STATUTORY PLANNING CONSULTATION RESPONSE

Application Number:	3/2026/0312
Proposal:	Approval of details reserved by condition 14 (drainage) on planning permission 3/2021/0760.
Location:	Springwood Drive Whalley BB7 9XL Phase 2 Lawsonsteads

Lead Local Flood Authority Position

Drawing Title: **S104 LAYOUT**

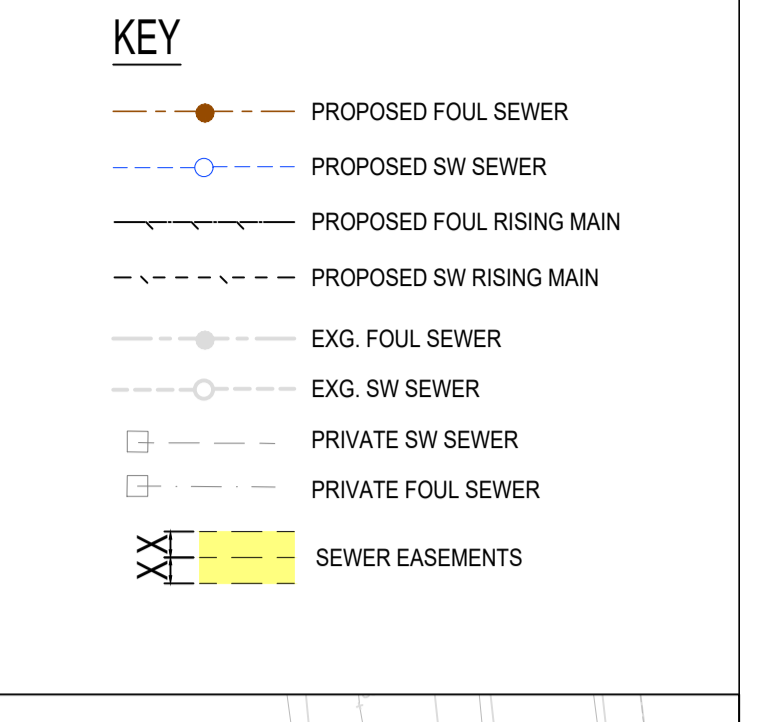
- The applicant has failed to provide evidence that the proposed drainage system will not exceed a maximum rate of 57.7l/s.
- The applicant has failed to provide evidence of a site layout plan showing flood water exceedance routes, both on and off site.
- The applicant has failed to provide evidence of drainage calculations that demonstrate the proposed drainage system, that include design storm period and

intensity, appropriate parameters and additional uplifts, such as urban creep and climate change.

- The applicant has failed to provide evidence of temporary surface water storage facilities.
